Re: Project # 1006864, Case # 17EPC-40004 Site Development Plan for Subdivision Amendment

The purpose of this letter is to explain how we have addressed the Environmental Planning Commission's (EPC) Conditions of Approval for Project # 1006864, Case # 17EPC-40004, for Final Sign-Off by the Development Review Board (DRB) of the Site Development Plan for Subdivision Amendment. The Environmental Planning Commission approved the Site Development Plan for Subdivision Amendment on May 11, 2017.

Project# 1006864
17EPC-40004 Site Development Plan for Subdivision
Amendment

1 4/28/17 Amendment is to allow for exceptions to the height regulations of the Northwest Mesa Escarpment Plan on 5 lots.

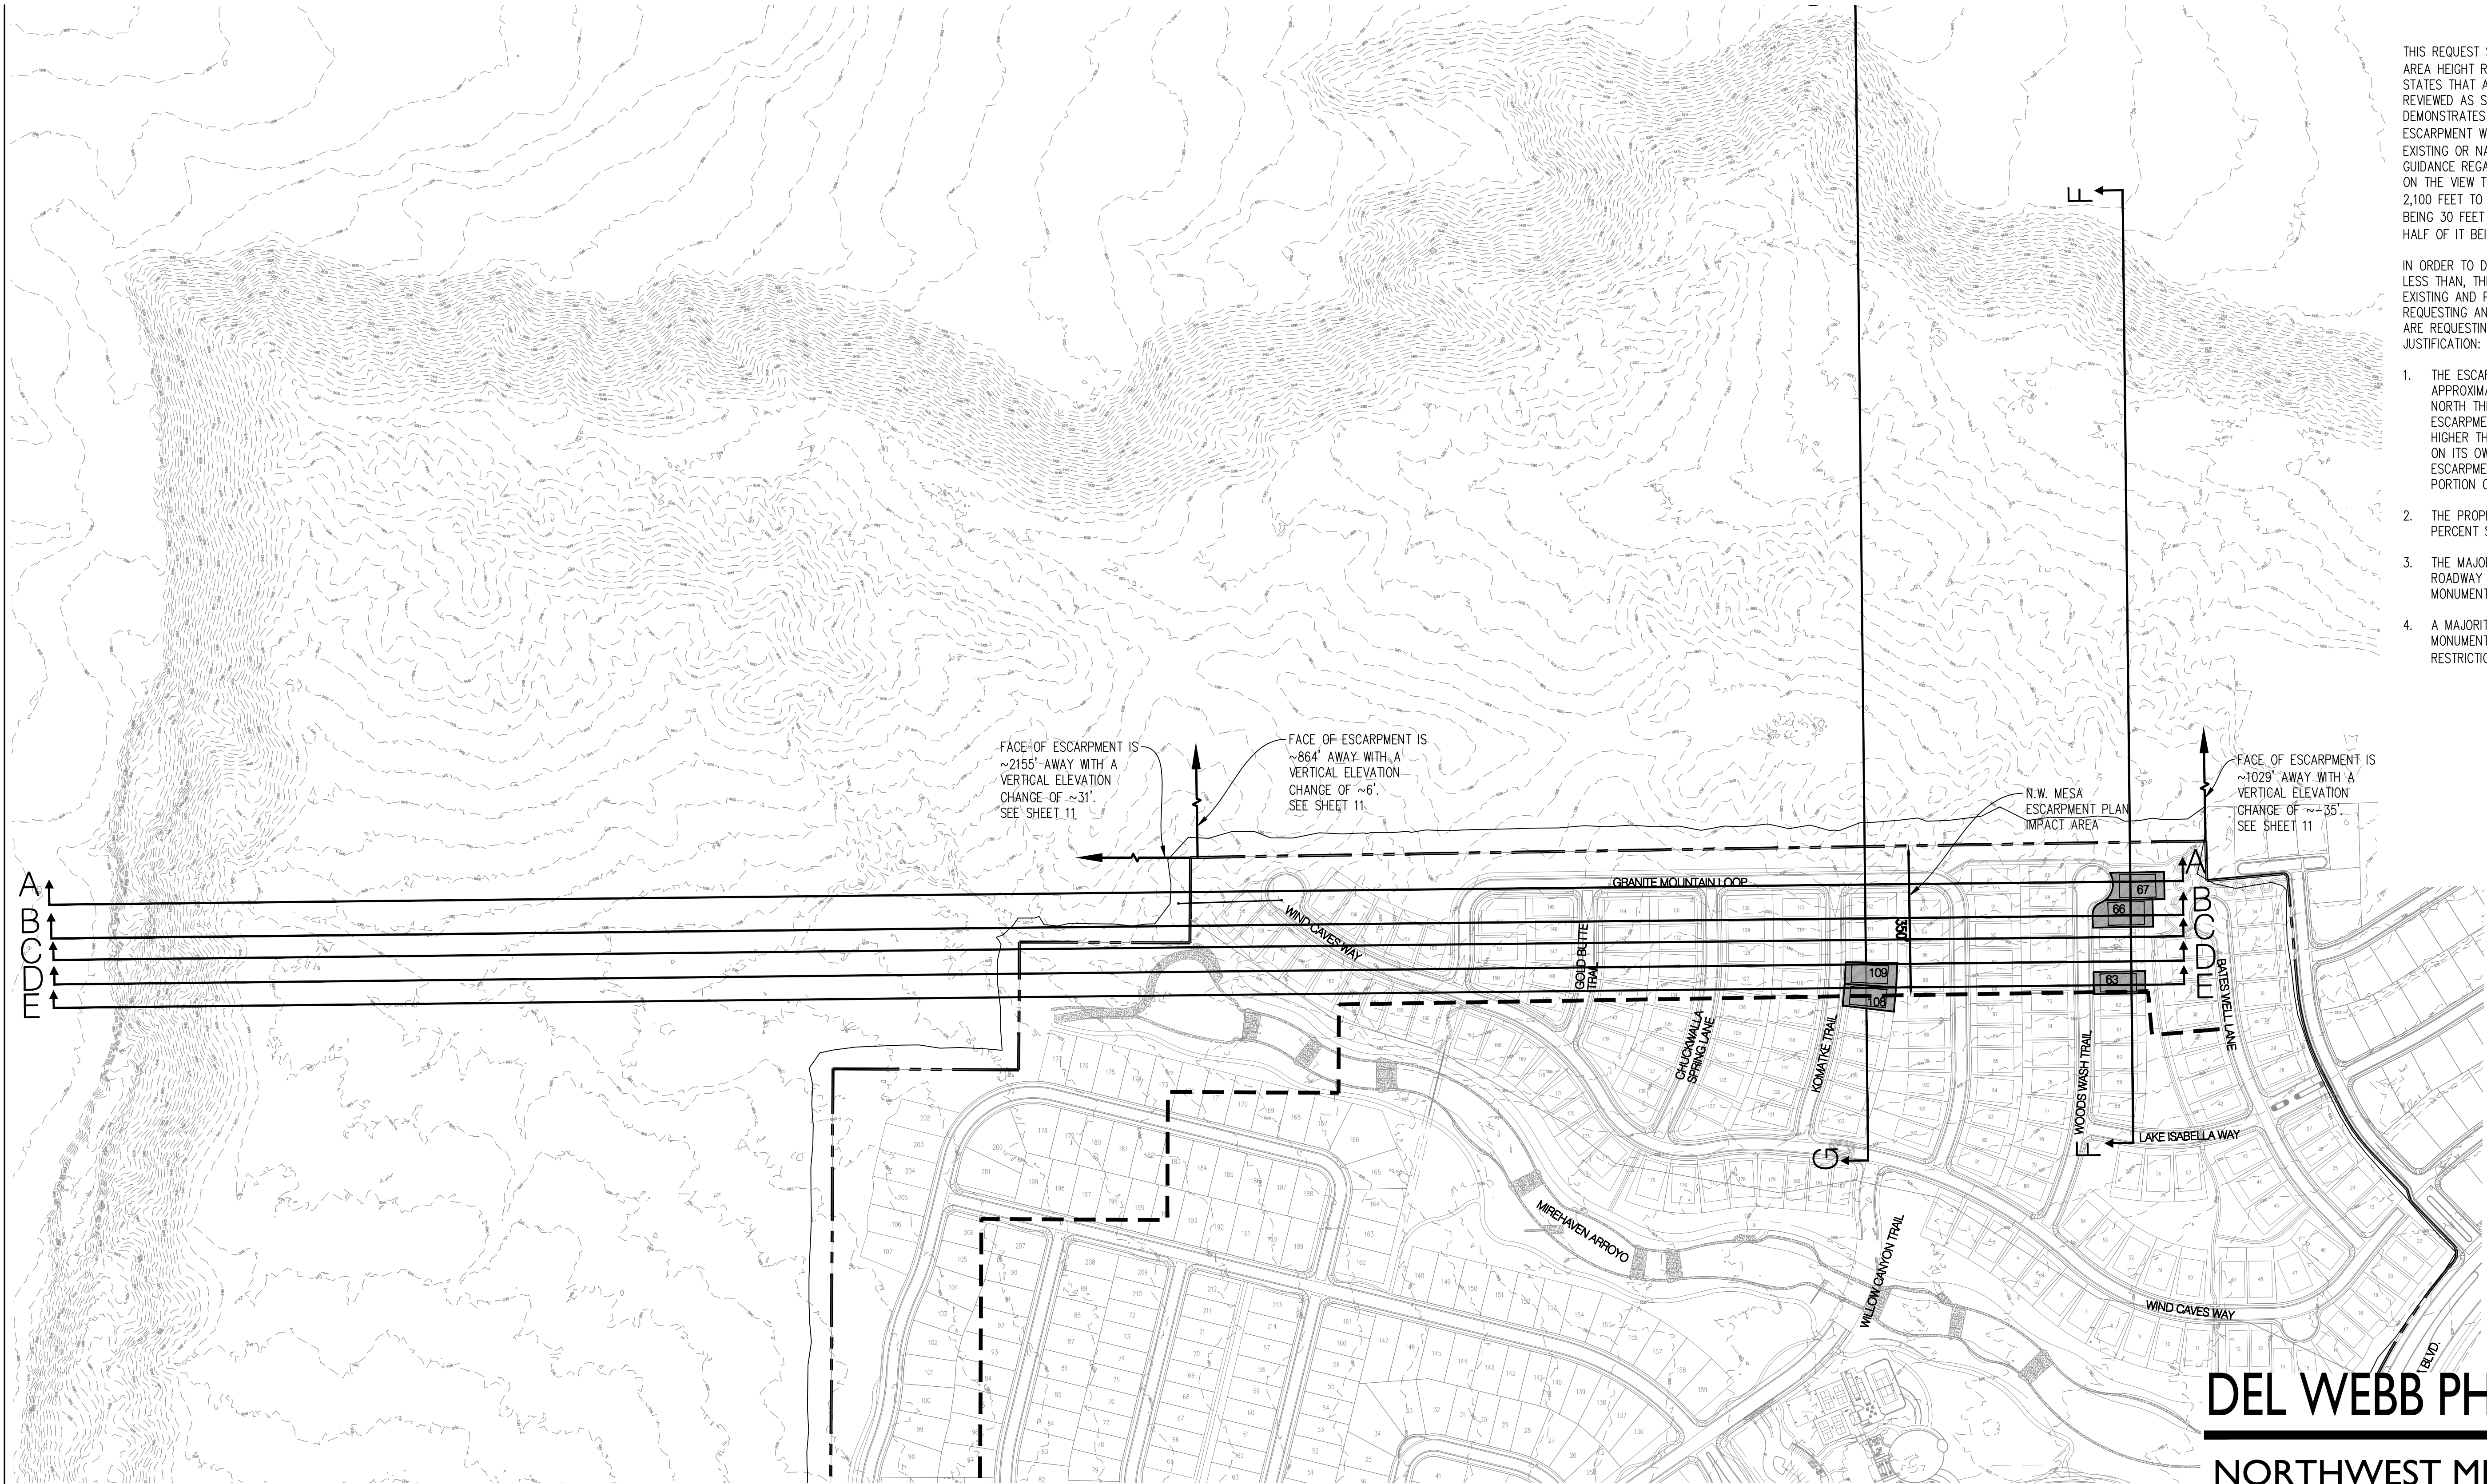
3. Height on lot 67 shall be limited to 17.8 feet from finished grade.

Hello Petra,
Please amend the map and table to show the 5 lots, not 7. If that happens I am happy to just review as part of the DRB process.
Happy Weekend!

The Site Plan states that the height is limited to 17.8 feet from finished grade, see sheet 2 and revised table.

Good morning Maggie,
Good catch! I put the signature block on the wrong set of site plans. Please see attached. This should show the 5 lots and not the 7.
Kind regards,

Condition 3 states "Height on lot 67 shall be limited to 17.8 feet from finished grade.". The revised table on Sheet 2 shows the height within this limit.
